NSW GOVERNMENT
Department of Planning

Our ref: 09_0019
File: S09/00106

Subject: Proposed tourist facility entailing 11 self-contained cabins, at Lot 4 DP 1022342, New Entrance Road, South West Rocks in the Kempsey local government area (09_0019)

NORTH ELEVATION

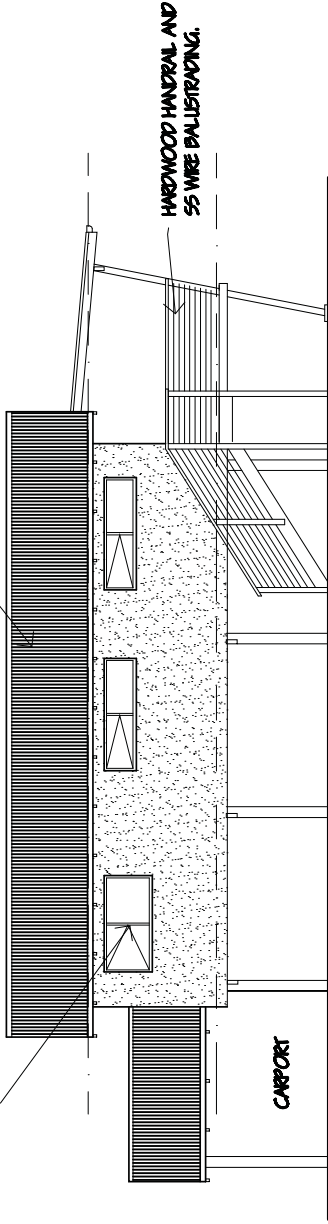
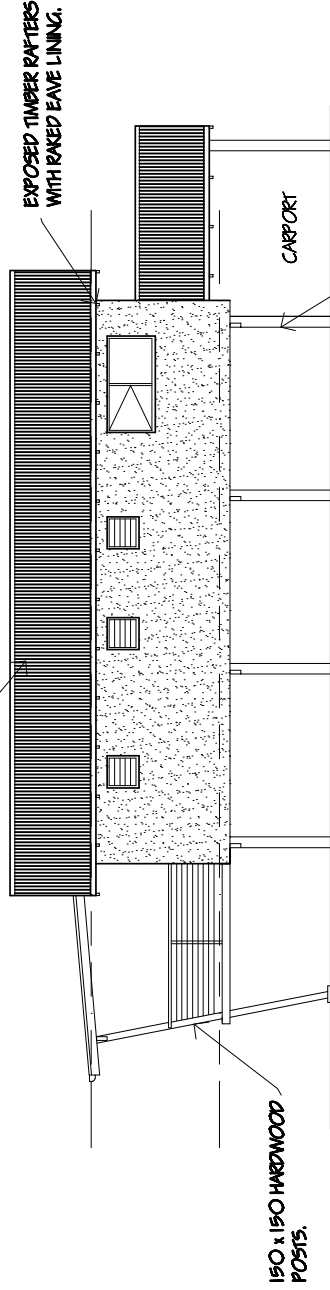
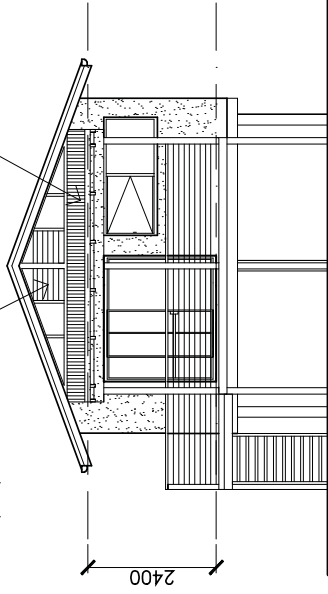
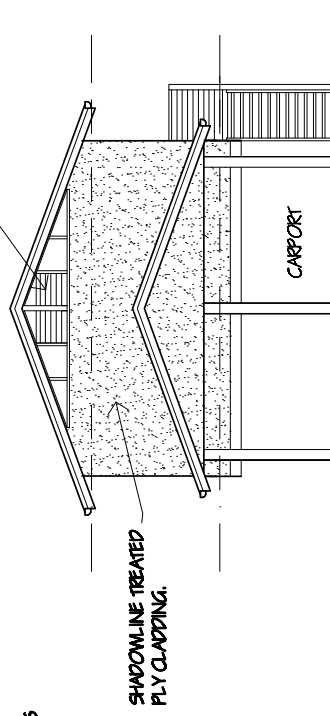
In addition, the design presented to date for the cabins on the southern side of the tavern is not supported. The cabins are bulky two storey buildings, exacerbated by the use of timber slats on all elevations at ground level. The structures should be open at ground level, and the size of the cabins-reconsidered.
